234338 SAAA

## **WSU Indigenous Centre of Excellence** **SSDA – Structural Integrity During a PMF Event**

TTW have reviewed the comments from the NSW Planning Department regarding the SSDA for WSU ICOE and have provided responses below. The original comments are shown in [blue](#)

Figure 35: Peak Flood Levels and Depths – PMF – Developed Condition

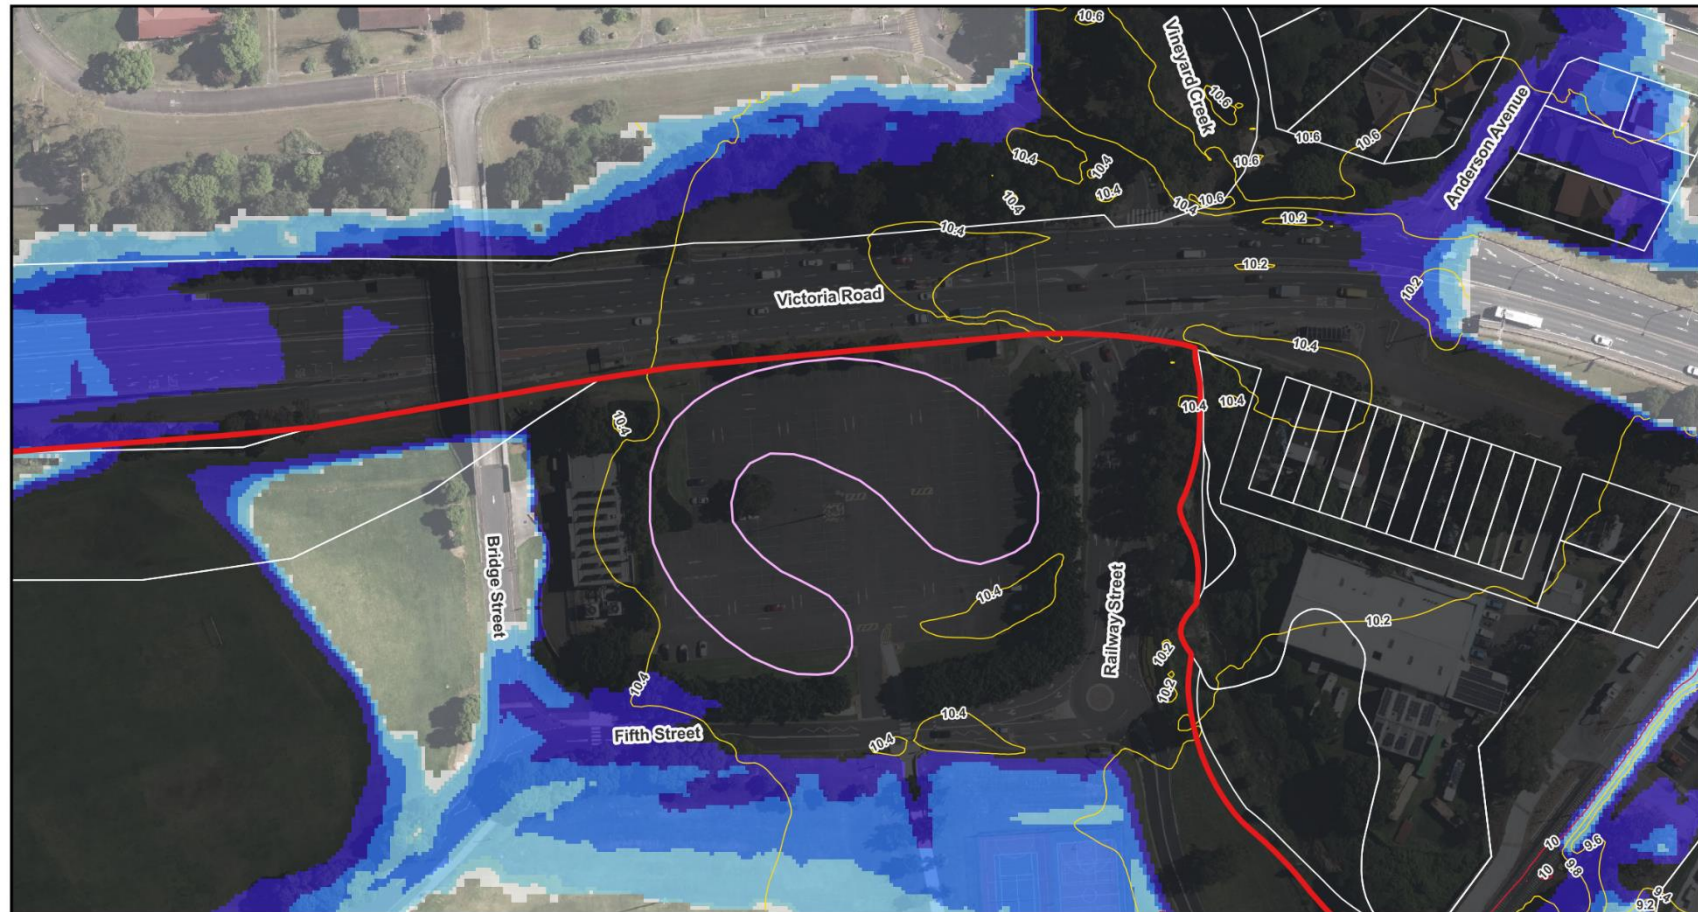
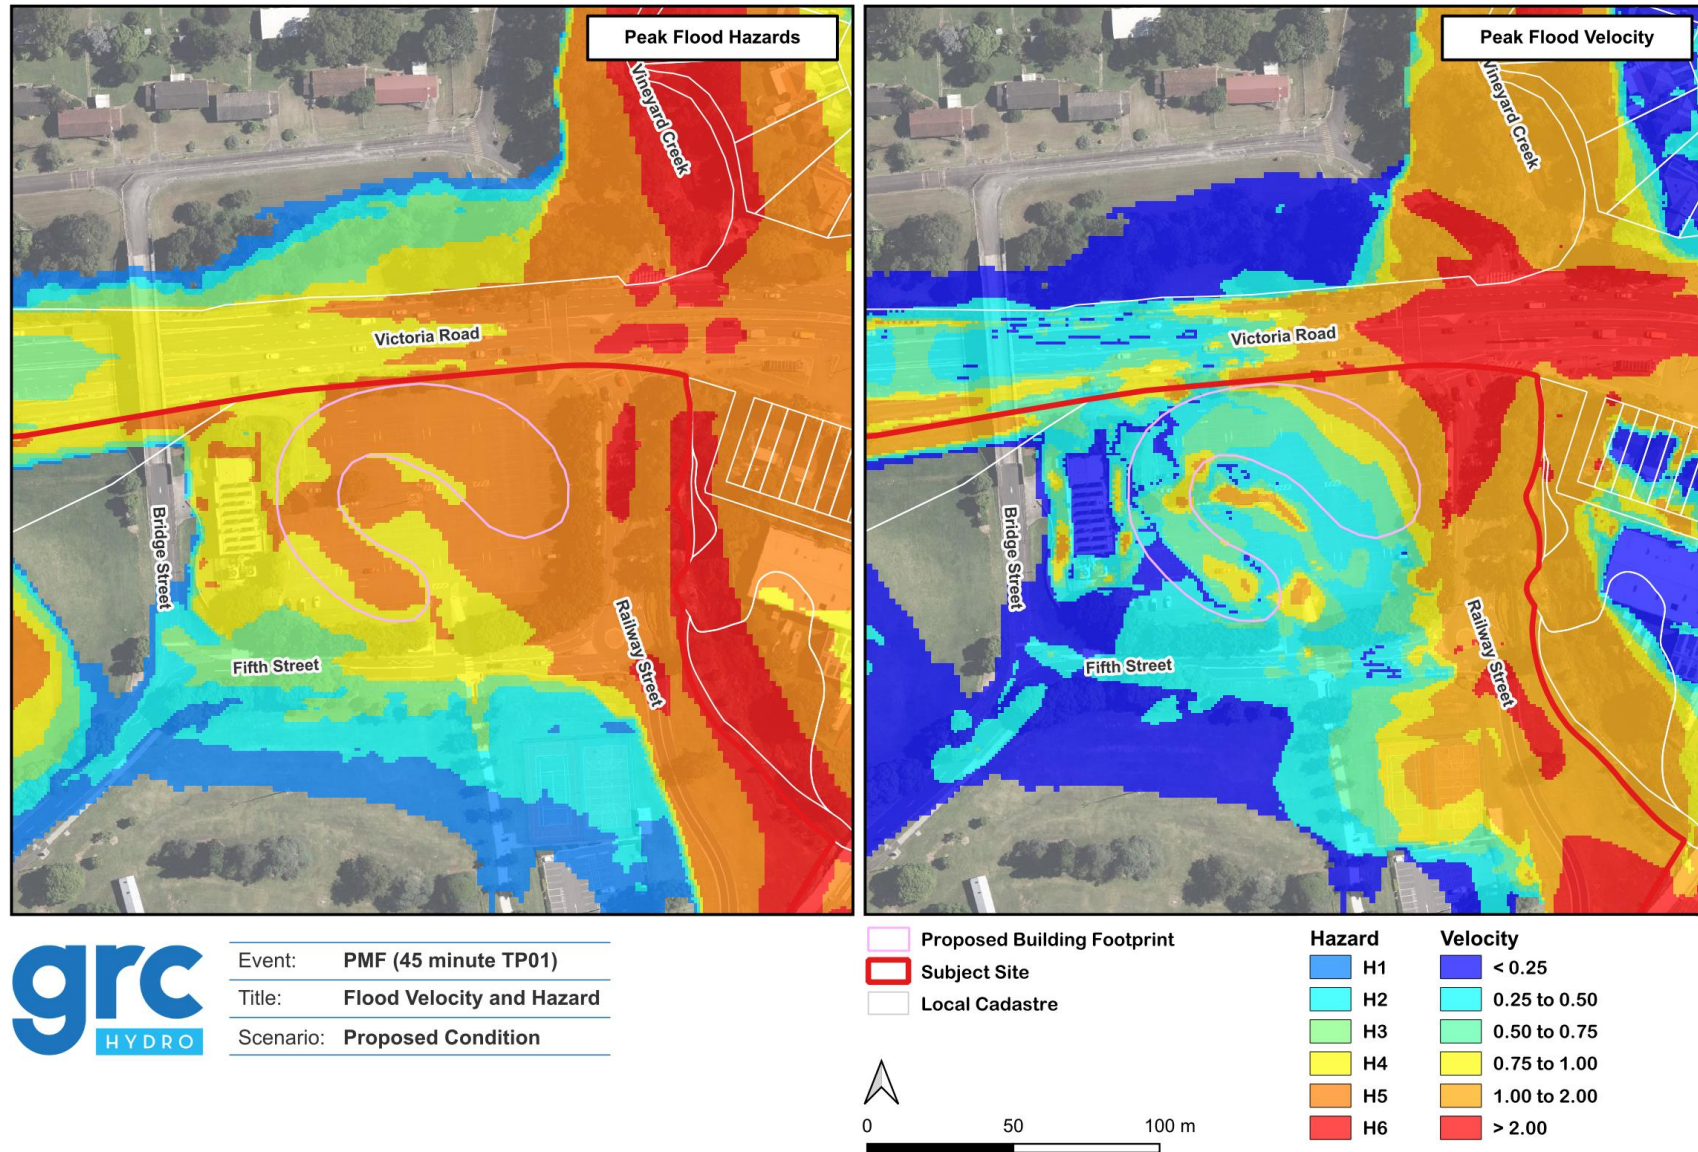
*Evidence from a certified engineer is required to confirm that the building can maintain structural integrity during a PMF event. Consideration must be given to the flood resilience of all building components.*

- Please confirm that the building structures will be designed to withstand the combined loads from occupants and staff, as well as any forces that may arise from flood water and debris during a PMF event, as per the finalised Shelter in Place Guideline for Flash Flooding.*

The flood modelling indicates that during a PMF event, the maximum water velocity will be 2.5m/s and will reach a point approximately 1.5m above the ground floor partially inundating the building for a period of approximately 1 hour. This equates to a horizontal load on the column base of approximately 42kN. This is noted as being below the 5% robustness load the column connections have been designed to as per AS1170.0 CL 6.2.3.

Furthermore, the force generated by the flood water on the ground floor is approximately 30% of the seismic loads the building has been designed for. As such, the building superstructure can be seen as sufficient to resist the forces generated by this water flow onto the superstructure while simultaneously carrying the load of the building occupants sheltering on the upper floors.

This means there is sufficient strength to maintain structural integrity during and immediately after the PMF event allowing for occupants to shelter during the event and evacuate safely once the flood water has subsided. Minimal debris is expected to impact the structure considering the numerous culverts, bunds and roads that provide an obstacle to potential debris.
